Your Ref
AL/64/18/DOC
Our Ref
PLAN-024088
Date
14/08/2018

Proposal: Application for approval of details reserved by conditions imposed under planning permission AL/75/14/OUT relating to condition No.4 (Surface Water Drainage Details), 5 (Sewer Diversion Details), 6 (Cycle parking), 7 (Parking Spaces) & 9 (Construction Management Plan).
Site: Land to rear of Woodgate Farm, Hook Lane, Aldingbourne, PO20 3SS
AL/64/18/DOC

Job title:	Development at rear of Woodgate Farm
Drawing title:	Proposed Soakaway Details
Drawing number:	17-(01) 104
Client:	Guilfoyle Construction Ltd
Revision:	P2
Date of revision:	10.07.2018
Revision detail:	minor revision to included recessed cover & other changes.
Status:	PRELIMINARY

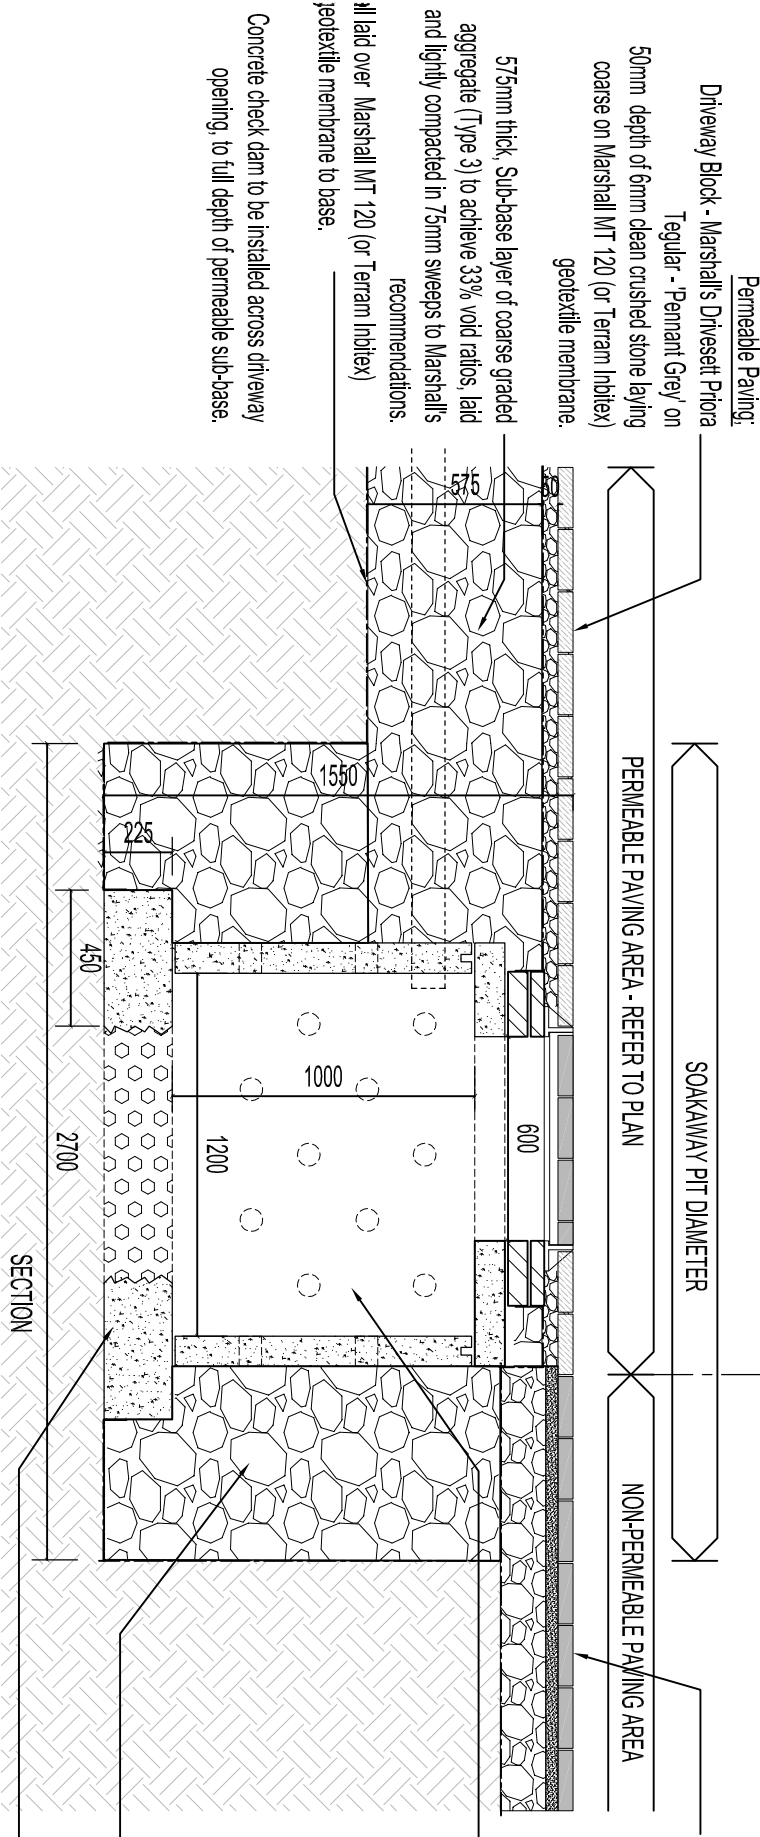
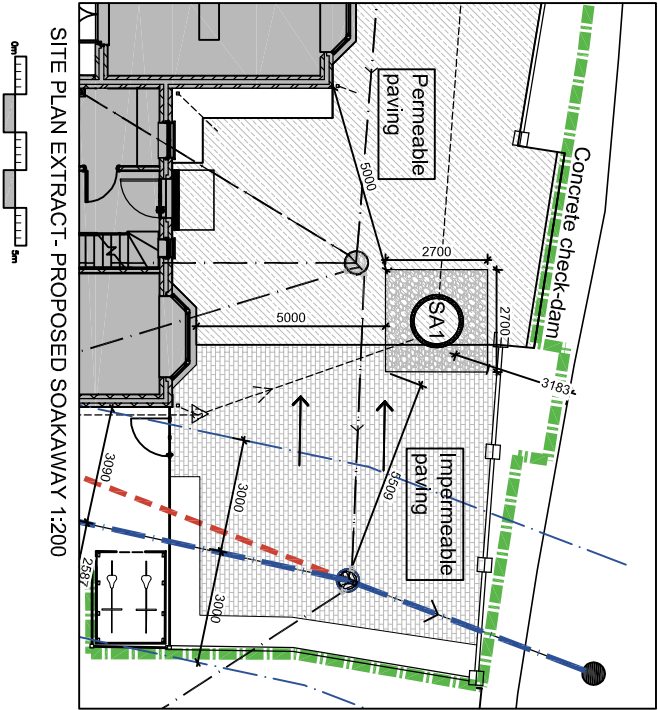
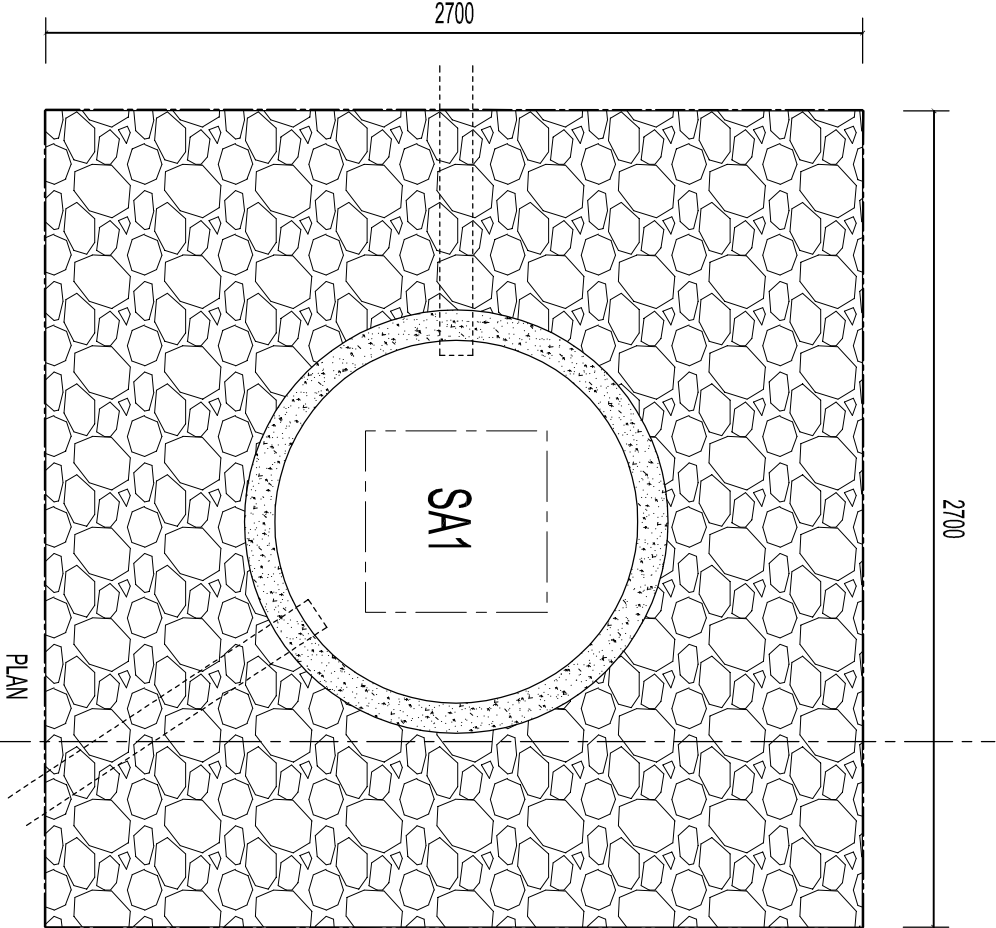
The location of the proposed soakaway results in the on site foul drainage serving the proposed two dwellings not being designed to adoptable standards and Southern Water requirements, so consequently should the drainage be built as shown, Southern Water would not be prepared to enter into an agreement to adopt the sewers or accept them in the future under any change of government legislation. The developer shall source a private maintenance company to maintain and repair the foul sewers within the site boundary.
